ACOUSTICAL INVESTIGATION &
RESEARCH ORGANISATION LTD

DJB/KH/6982/L2

Planning Application: 6/2017/0400/FULL

We write on behalf of our client, GPL 2014 Ltd, in relation to the planning application detailed above, and in particular to provide further information in reply to comments received from the Environmental Health Officer (EHO).

Drawing: **Proposed Elevations North & East Elevations**

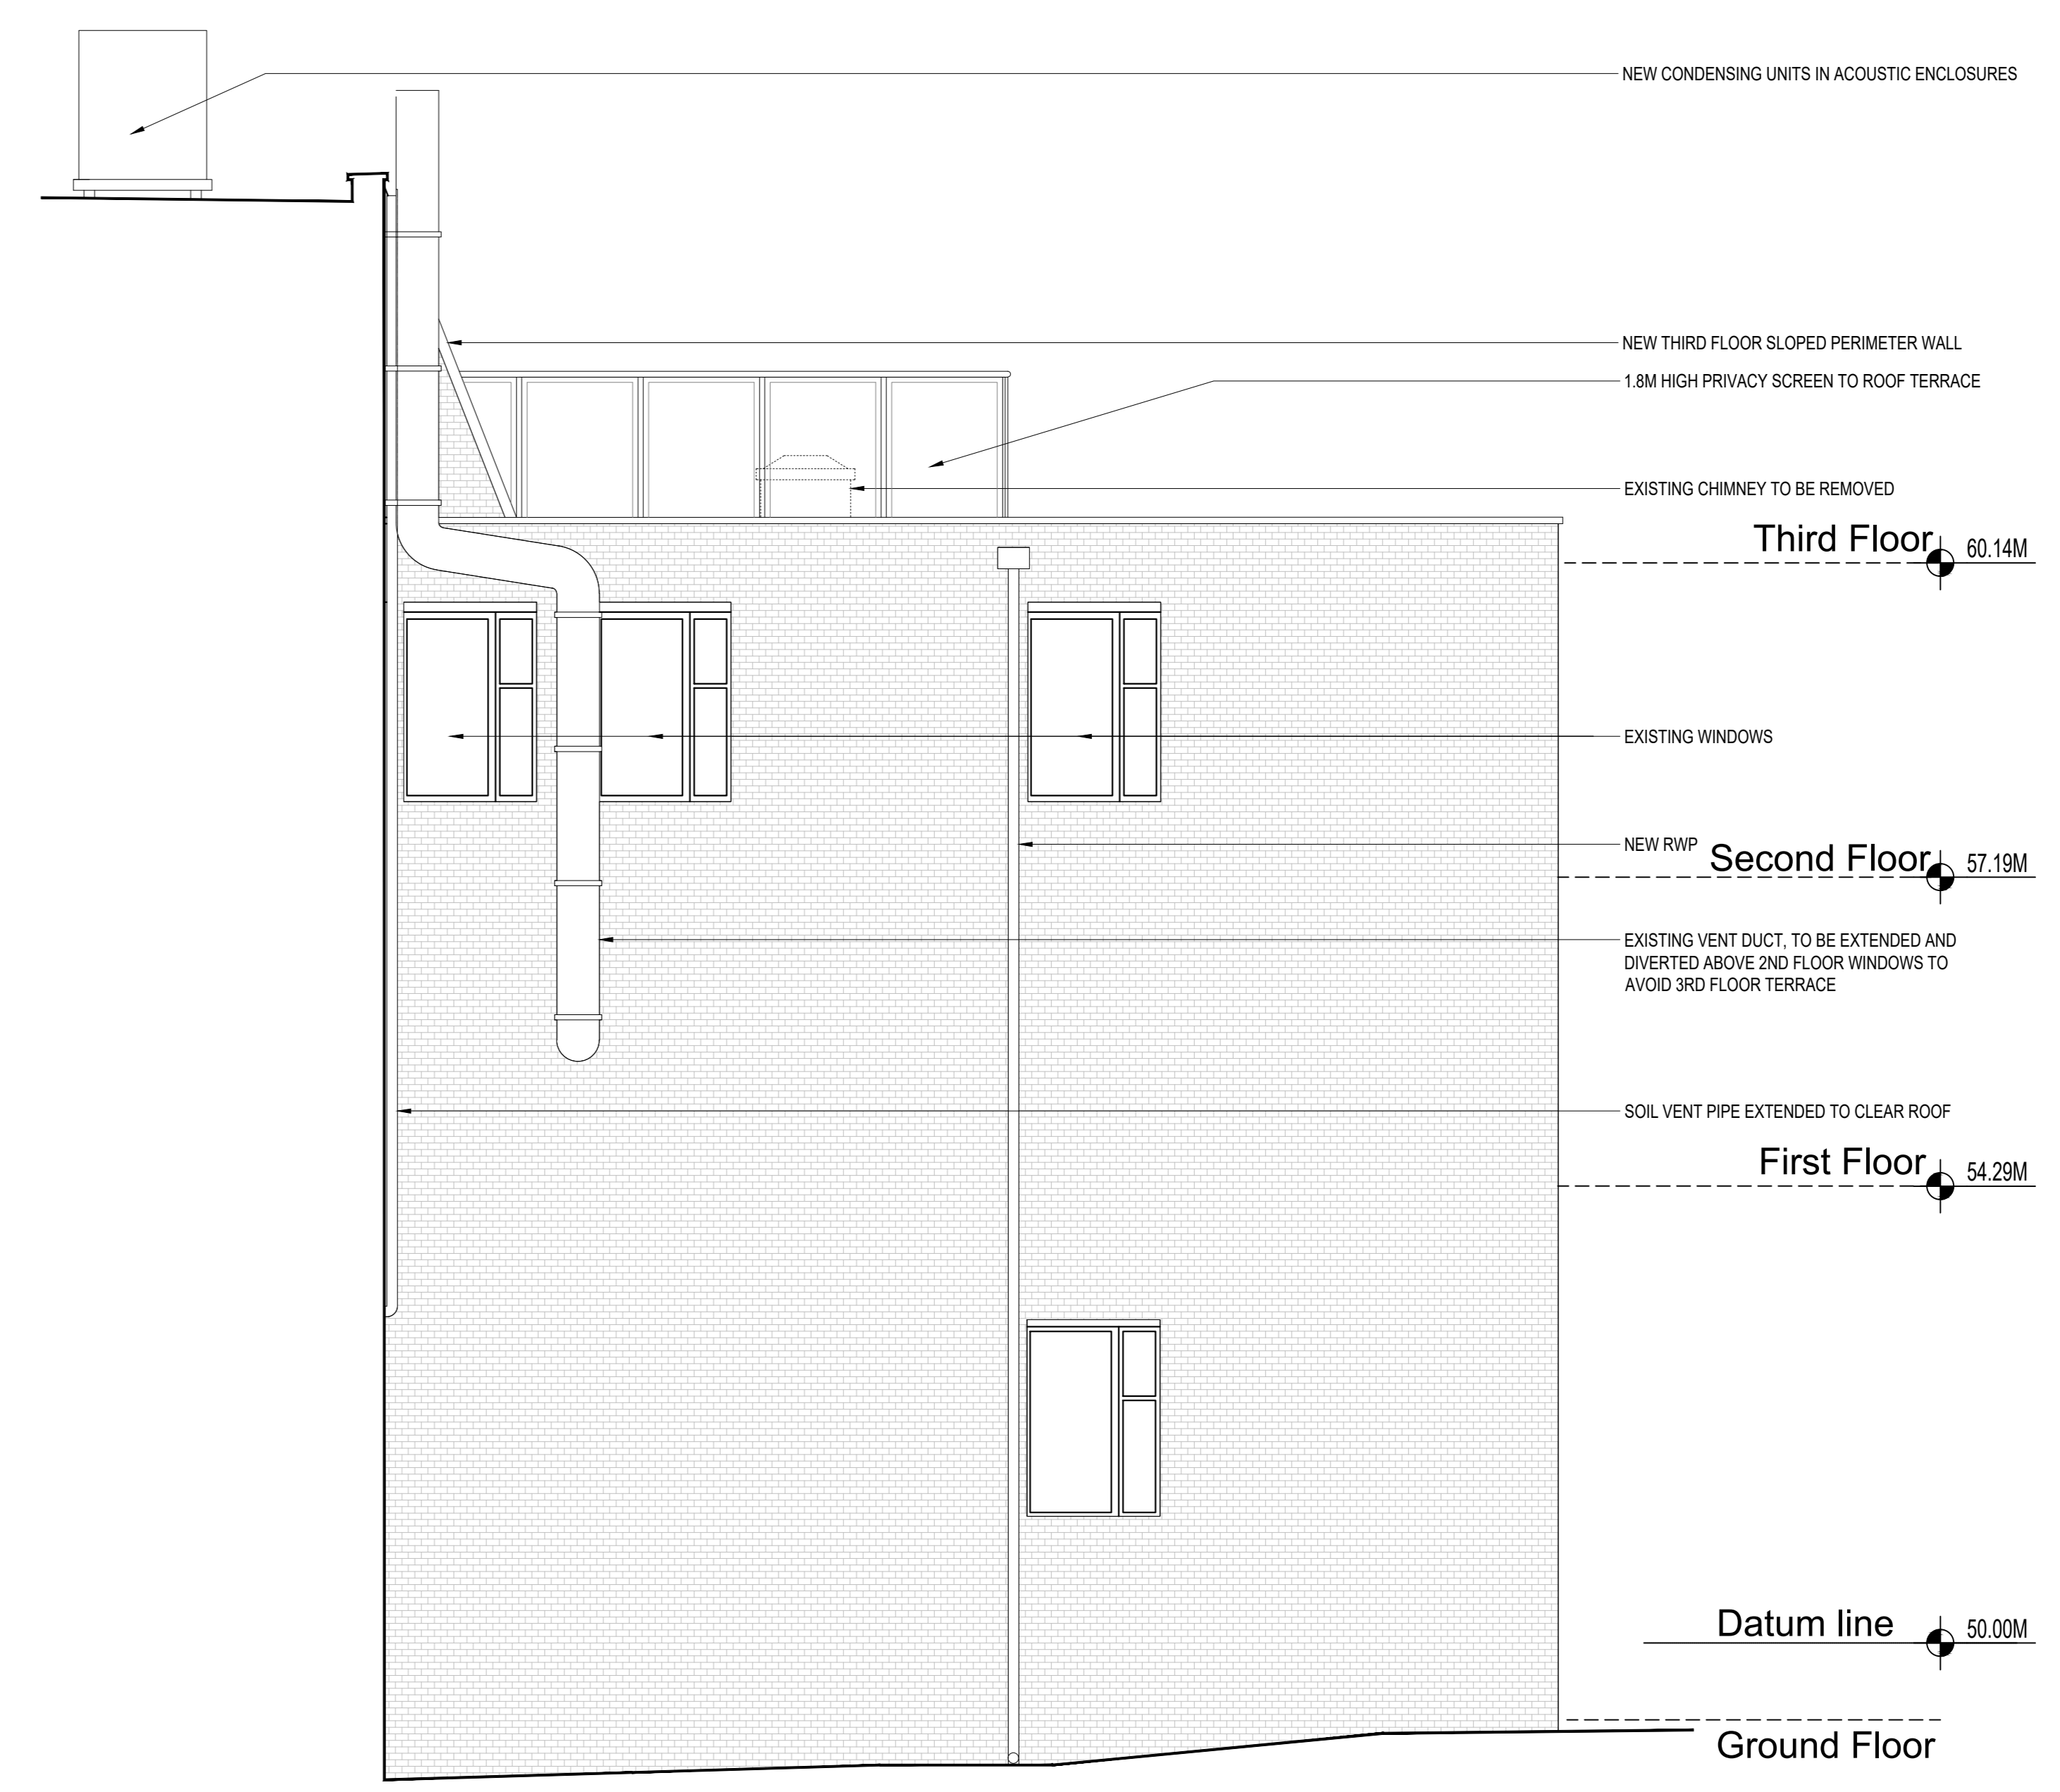
3. The author of the noise report has suggested that mitigation measures are perceived to be required? to limit noise and/or vibration from the restaurant/pub ducting. This comment is not helpful, as the consultant must explain whether additional mitigation is necessary or not necessary to deal with noise or vibration. If they are needed then they must state so. In any event the ducting is owned and operated by an different occupier and so there is no provision in the planning application for requiring non-applicants to modify their equipment.

7. The data was recorded 1st- 5th July 2106. I am not comfortable with using old data and in any event find it difficult if not impossible to believe that noise from the Club 67 (directly below) was not the dominant noise source. The extractor system from the restaurant has not been assessed using BS: 4142: 2014 despite the claim that this is a significant source. The acoustic consultant has not indicated or provided the actual number of LA Max "noise events" which exceeded 80dB they have simply stated the highest noise event level and not then explained the LA max level of 92dB.

Our report stated that in relation to the sample noise level measurement result of 55 dB L_{Aeq} , 1 metre away from the termination of one of the ducts, the facade mitigation measures outlined elsewhere in the report would reduce the indoor noise levels to below the World Health Organisation thresholds. Given that the noise emissions breaking out through the duct walling are likely to be lower than those emitted from the termination the proposed mitigation should be satisfactory.

With the above information in mind we consider that satisfactory mitigation can be provided and that if any further assessments are deemed necessary this could be secured through use of a condition attached to the planning consent with wording similar to that provided below:

“Noise from extract plant shall not exceed a rating level 10 dB below the representative background noise level 1 metre from the façade of the nearest noise

sensitive premises. Rating levels and background noise levels to be determined according to BS 4142:2014.”

Title
 HEATING & COOLING LAYOUT
 TYPICAL FLAT LAYOUT
 THIRD FLOOR

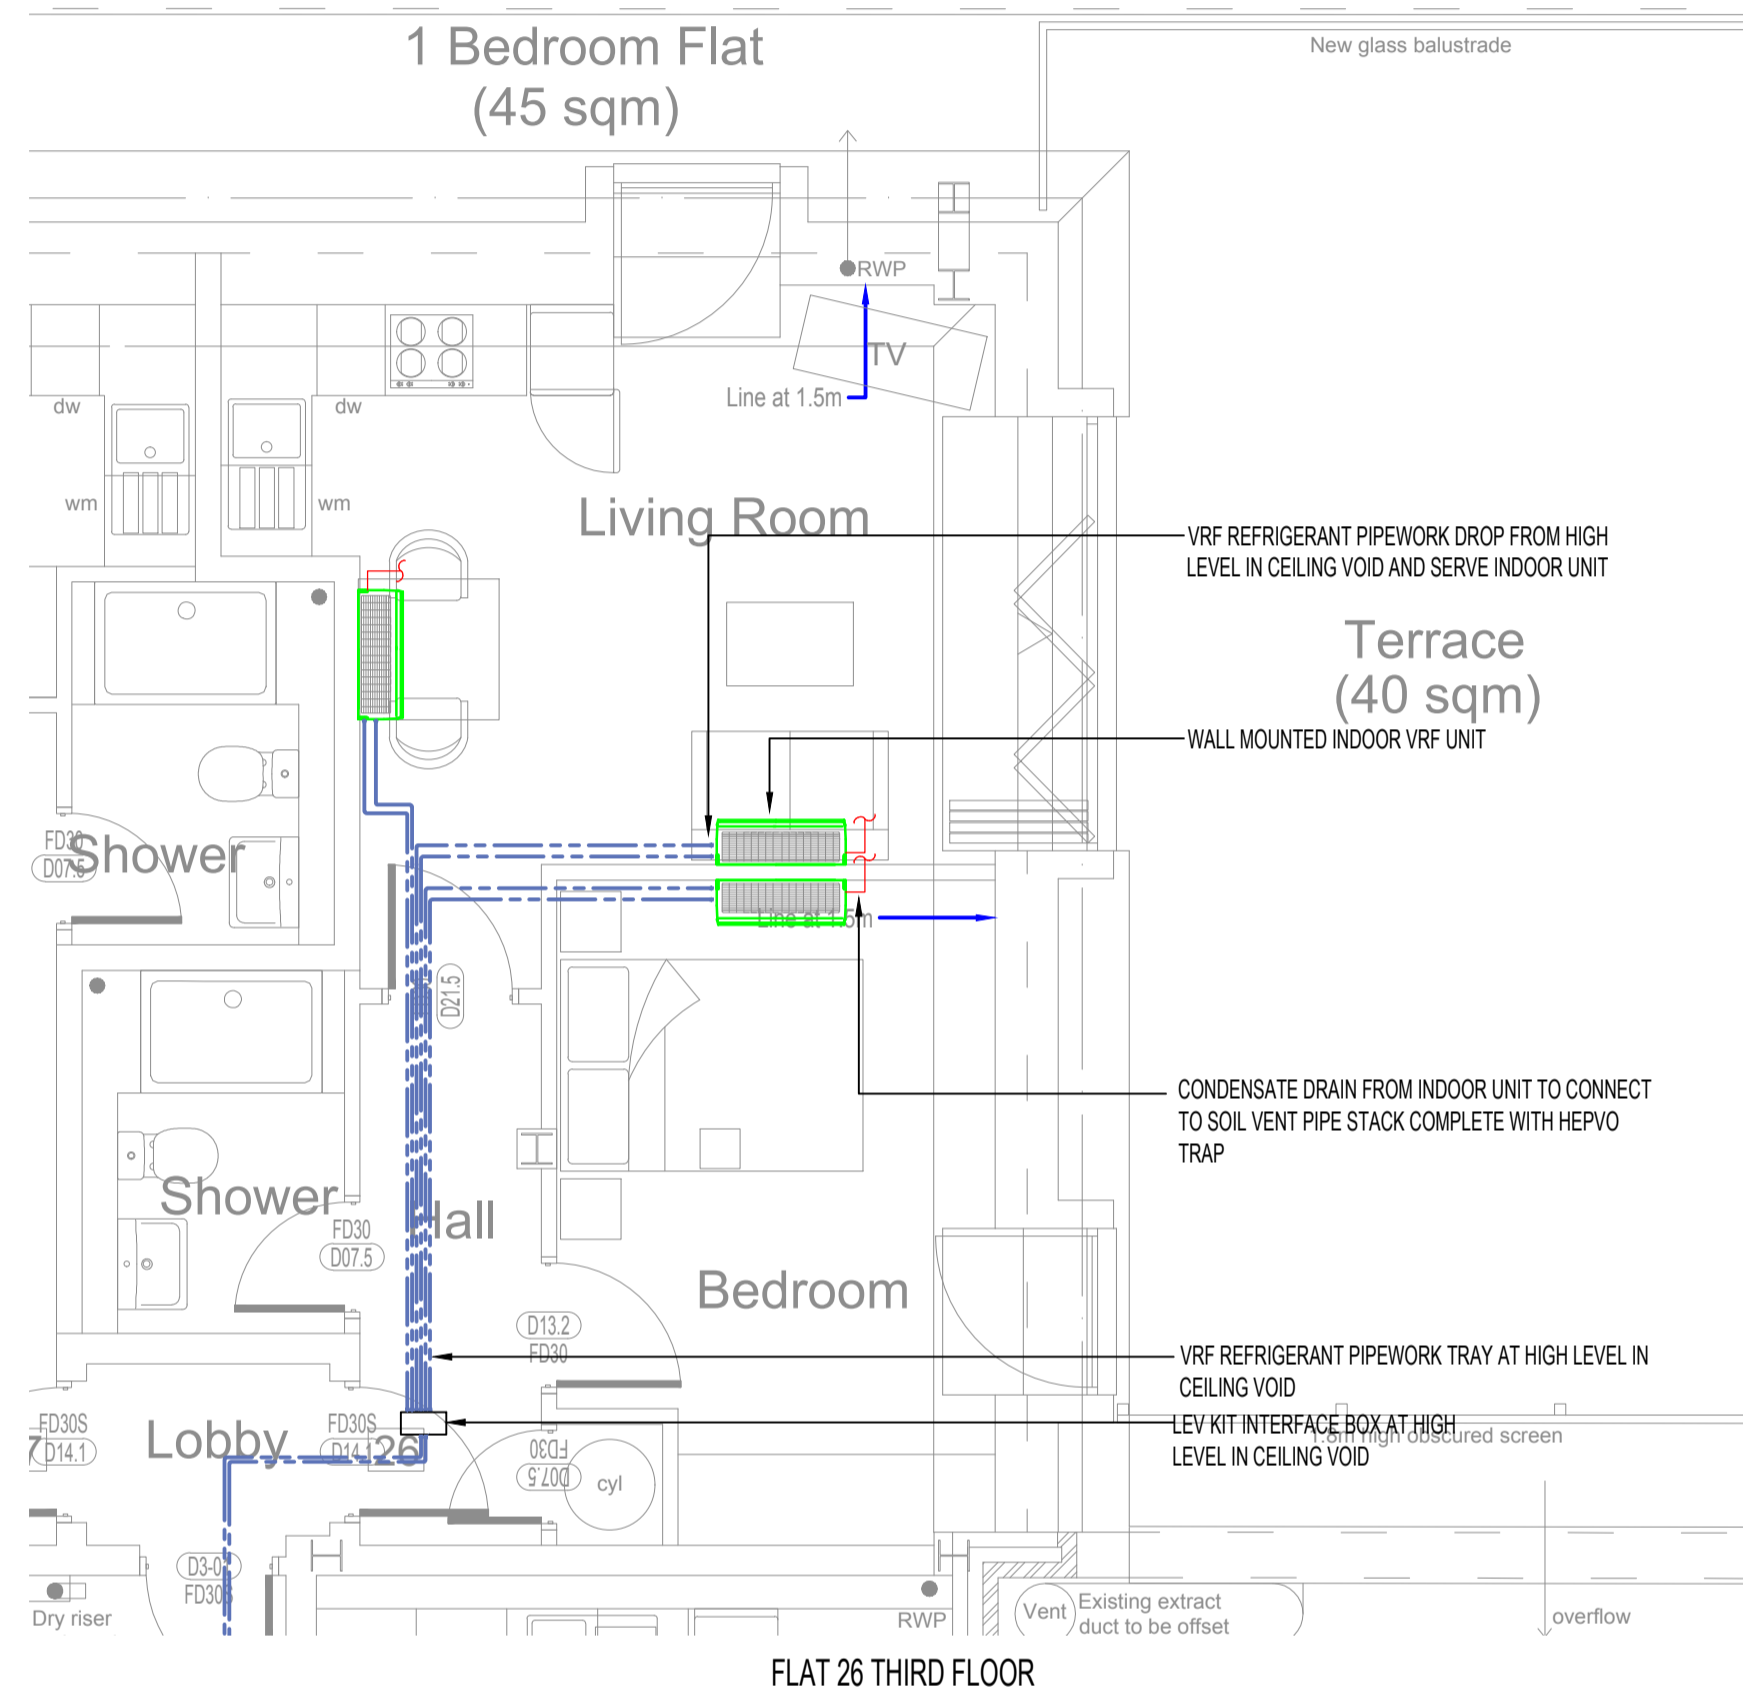
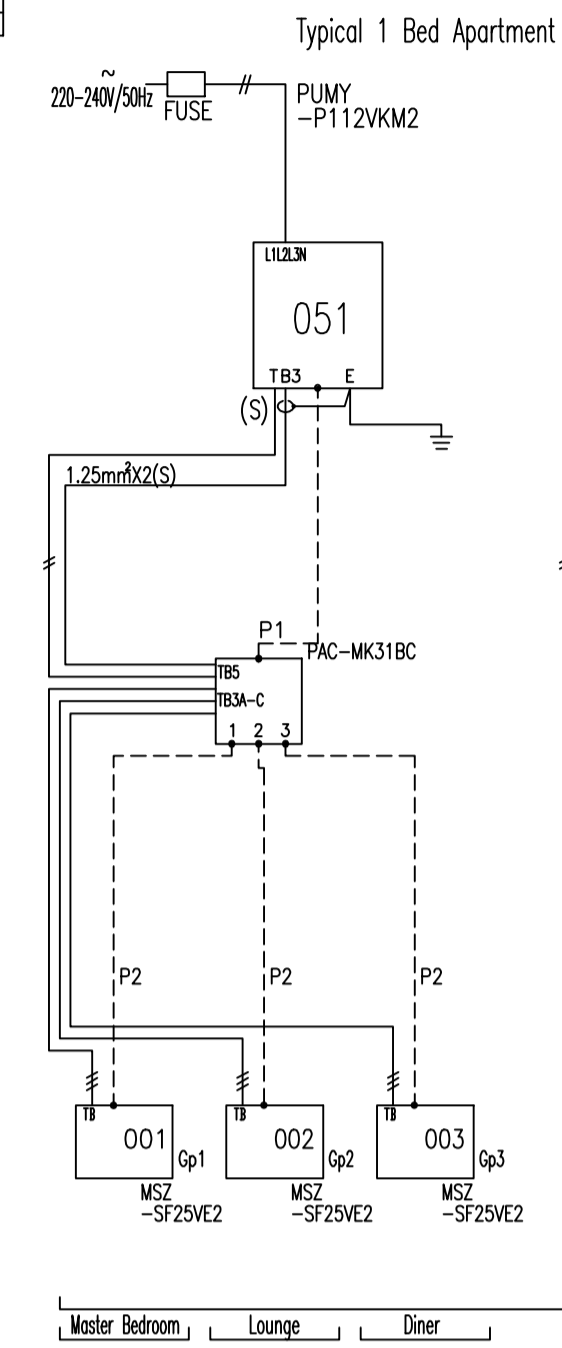
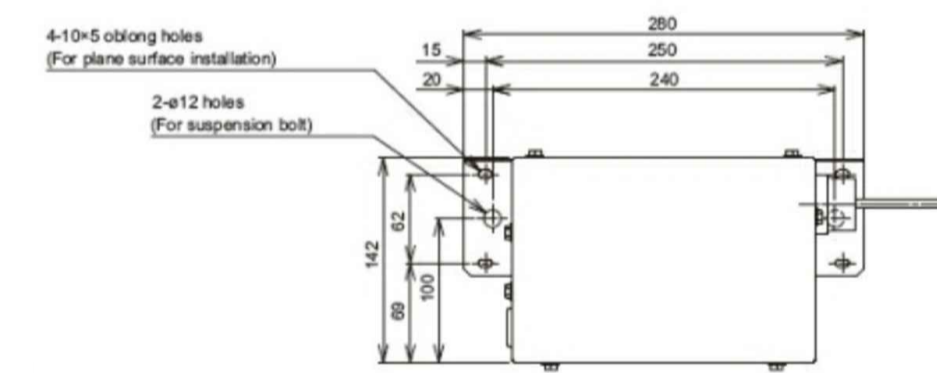
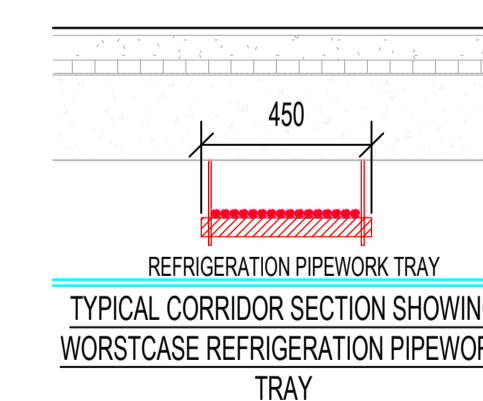
1. The mechanical ventilation system proposed takes no account of cooling matters. We require the following standards: A system that provides for purge ventilation during the summer months and for cooling provision that does not require windows to be opened. The report does not indicate that this is the system which will be installed (i.e. a mechanical heat recovery ventilation/cooling system).

"We are proposing that each dwelling will have air conditioning (heating and cooling) together with a mechanical extract system that complies with Building Regulations Part F- System 3. The specification of the mechanical ventilation is continuous mechanical extraction (with a boost setting) and supply via through-wall vents of high acoustic parameters in accordance with our acoustic report. Furthermore, regarding purge ventilation, the Building Regulations guidance on this matter is specific in three areas; continuous, intermittent and for the purposes of thermal comfort.

- *Lastly, where the issue of purge ventilation and thermal comfort is concerned, we are proposing to install an air conditioning system (heating and cooling) in each dwelling which will assist in the control and regulation of the local environment within the dwelling."*
